CITY OF PORTLAND BUILDING PERMIT

PERMIT ID: 2013-00333 **ISSUE DATE:** 04/11/2013 **CBL:** 131 H011001

has permission to **Create One Handicap Family unit - removing 2nd kitchen facilities & add new deck**

Proposed Use: Change of Use from two family to Single Handicap Family Unit (no more than 16 beds)	Proposed Project Description: Create One Handicap Family unit - removing 2nd kitchen facilities & add new deck
-------------------------------------------------------------------------------------------------------------	--------------------------------------------------------------------------------------------------------------------------

A3.1

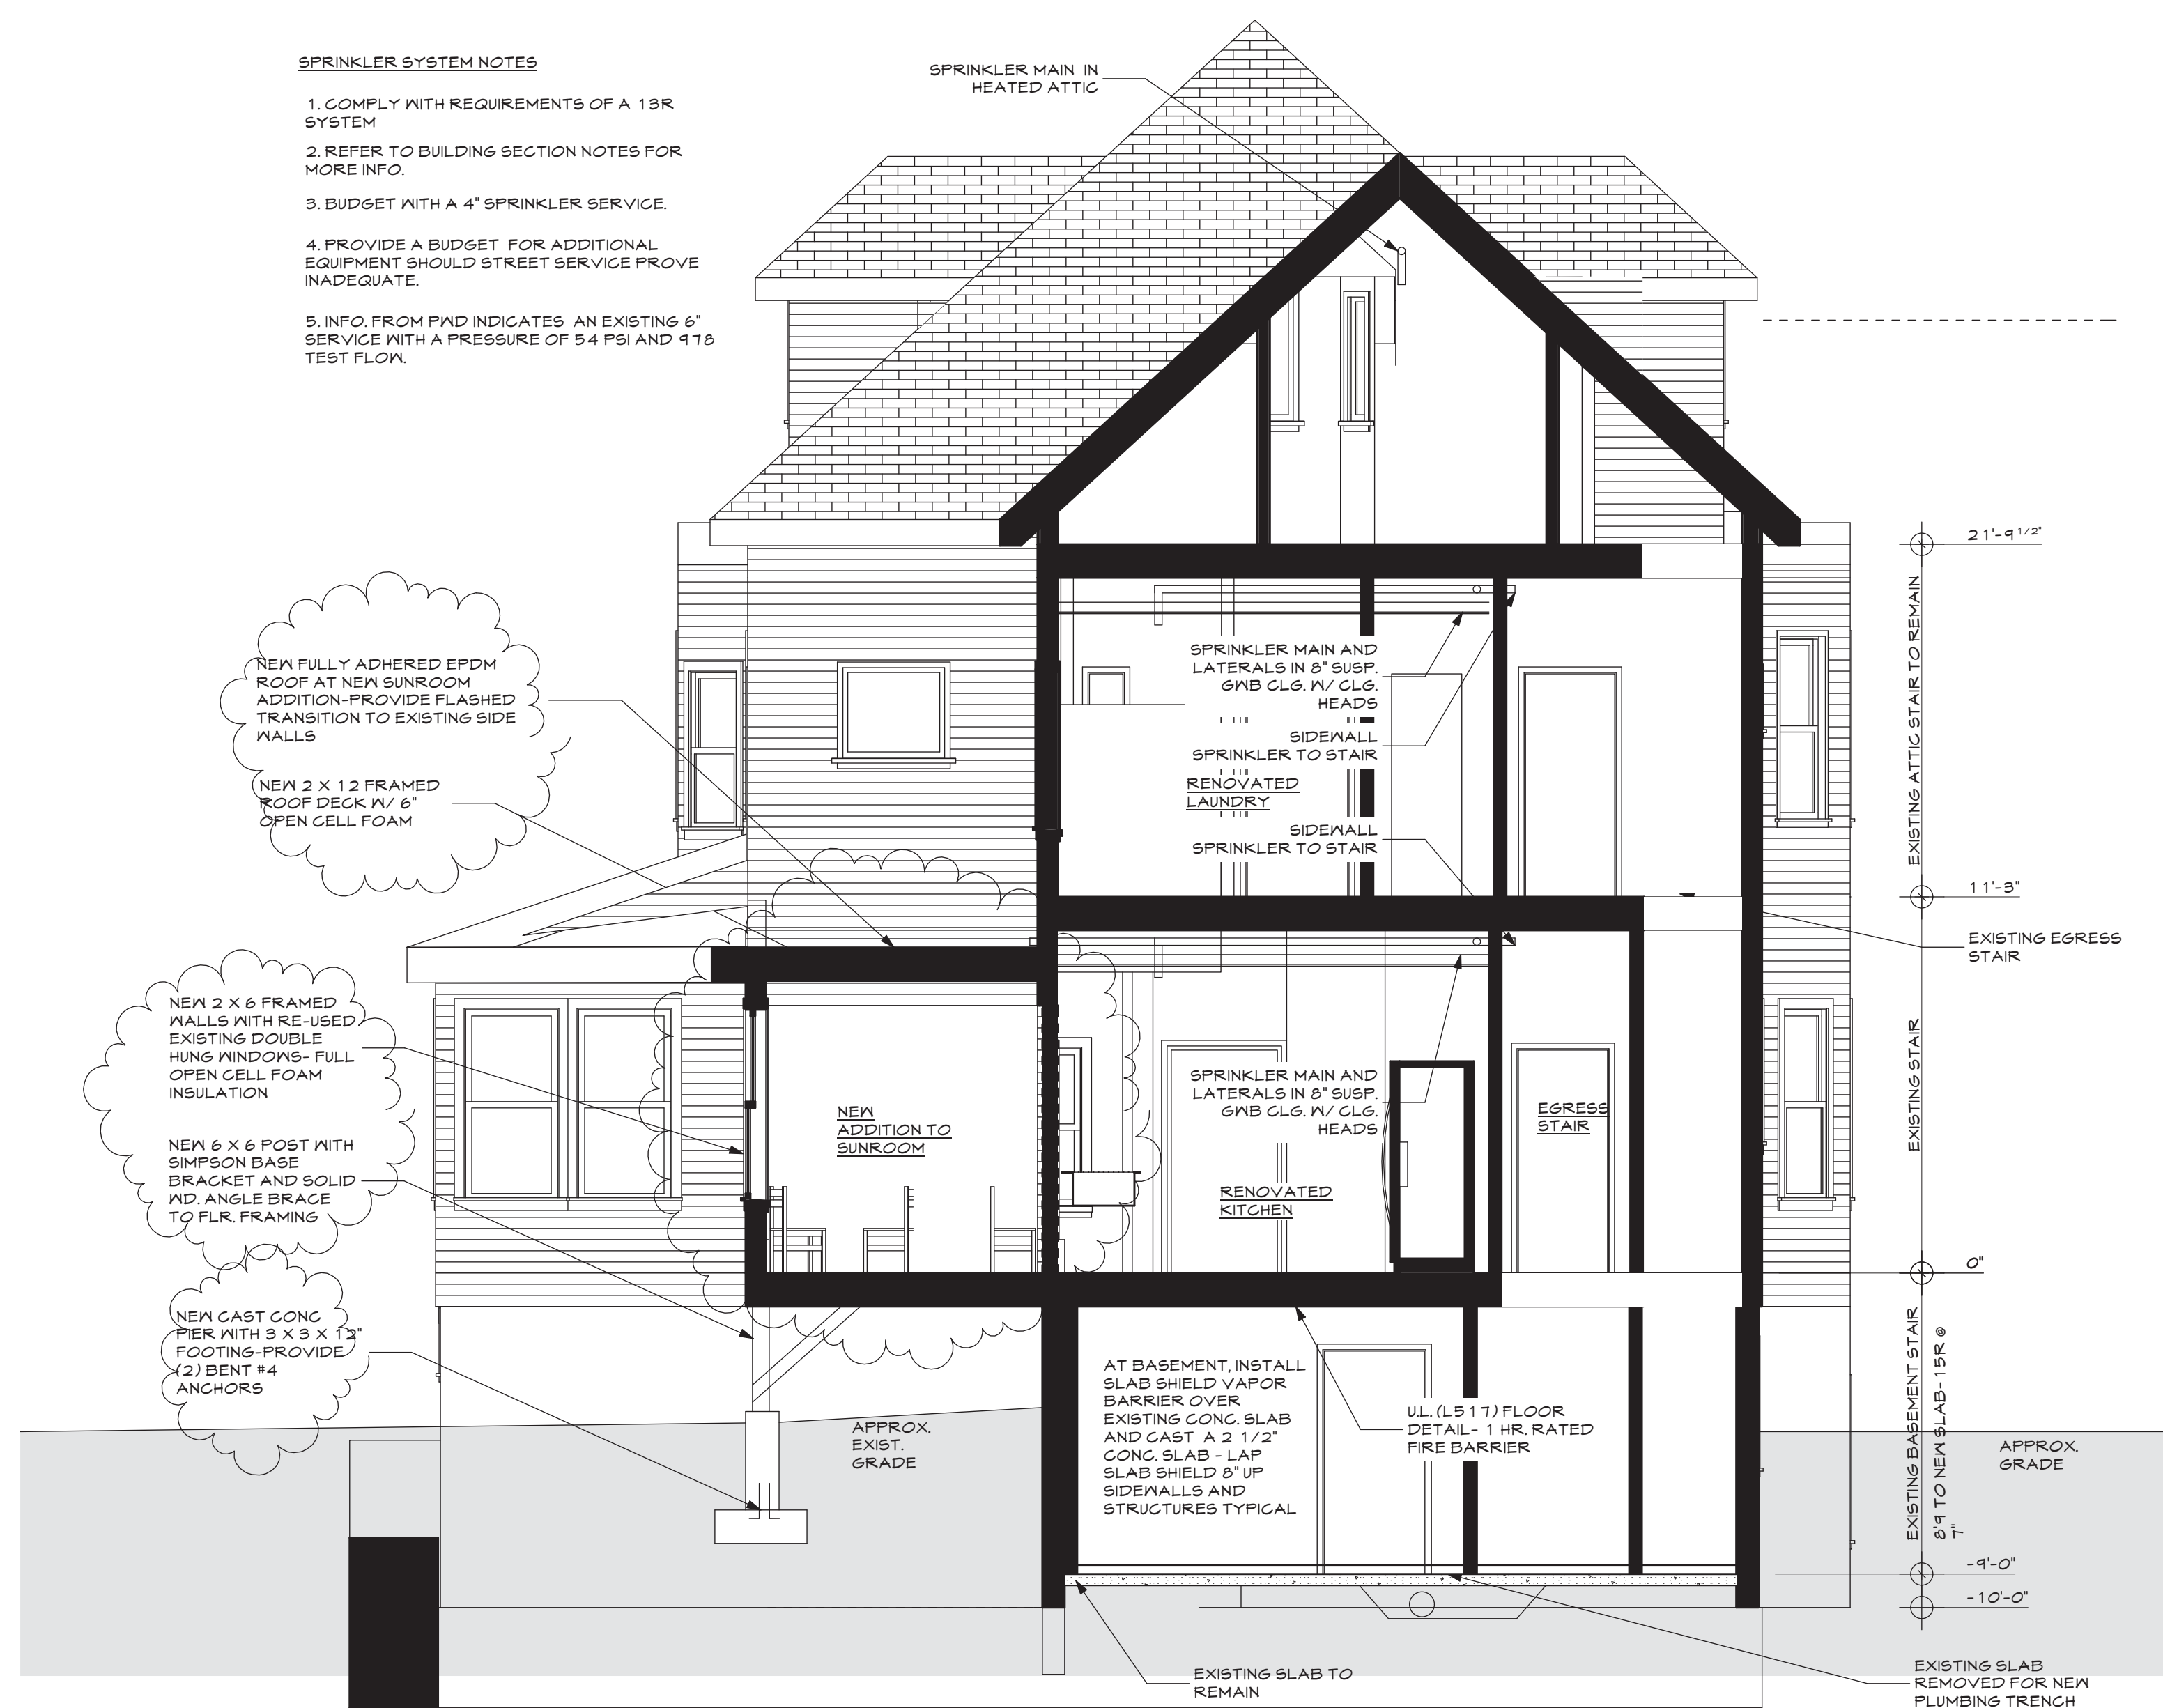
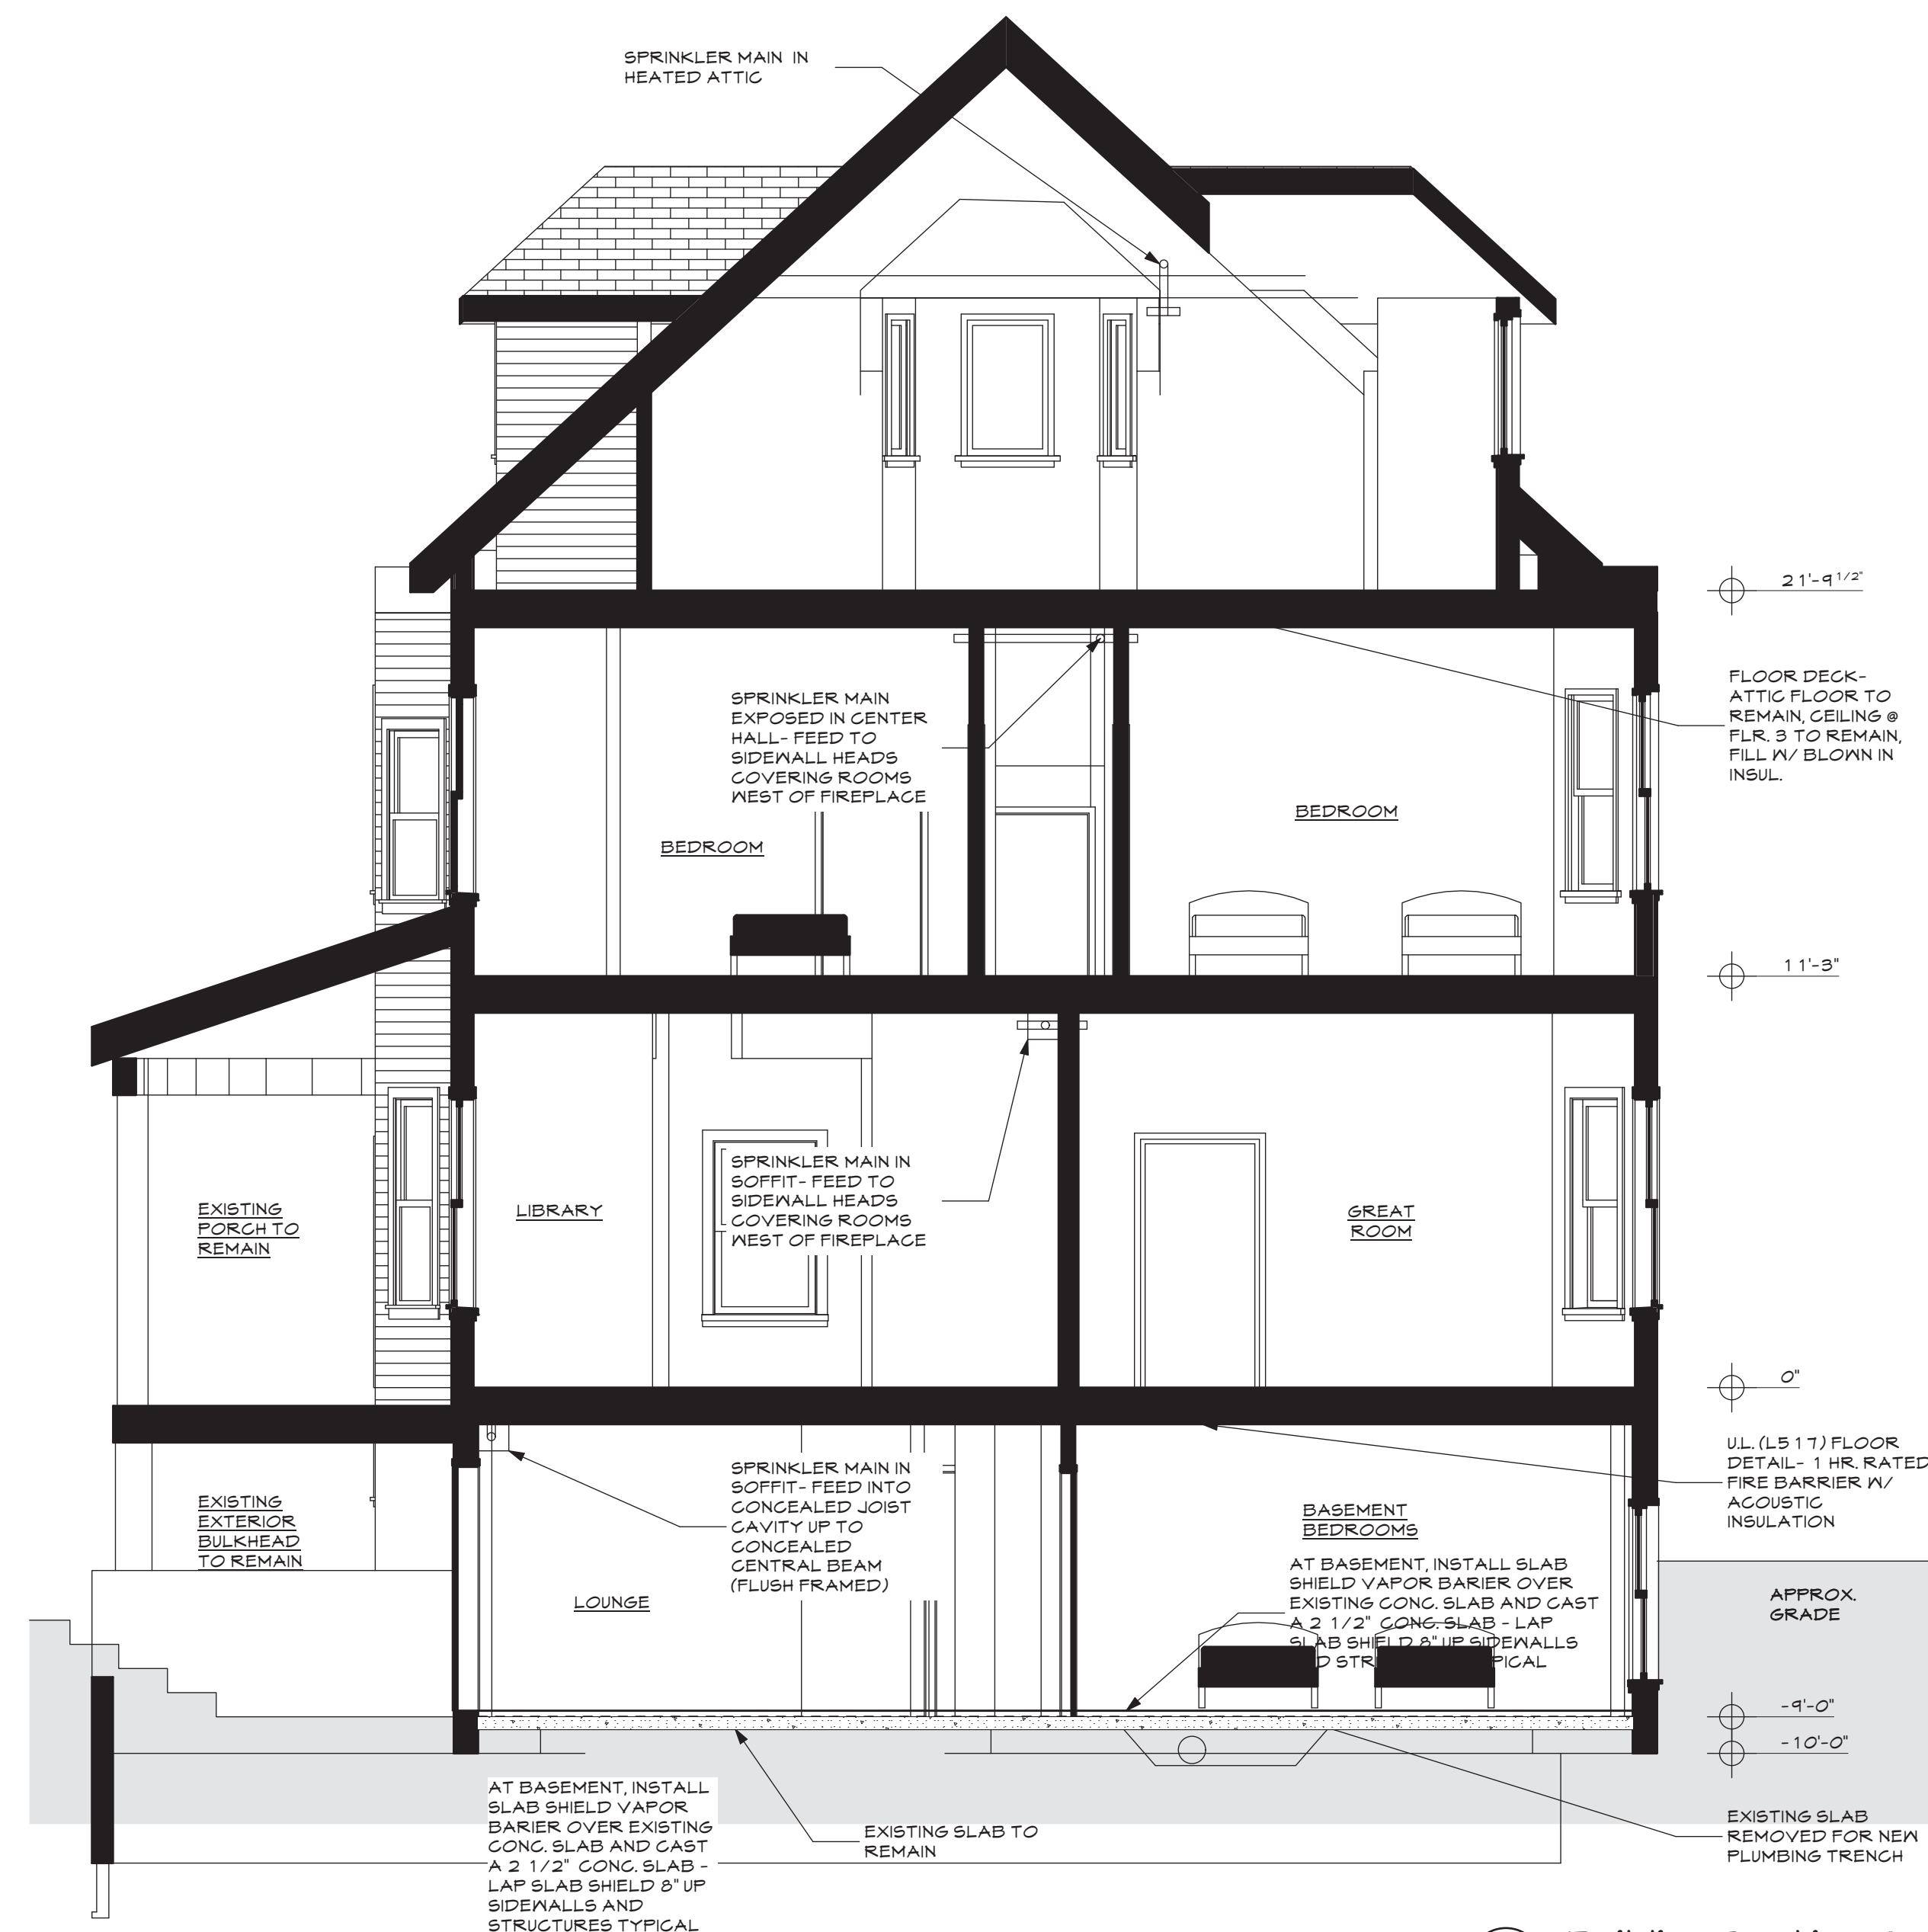
A3.1

Define Grade Plain vs Level

Framing Detail for wall additions

Explain use of Attic
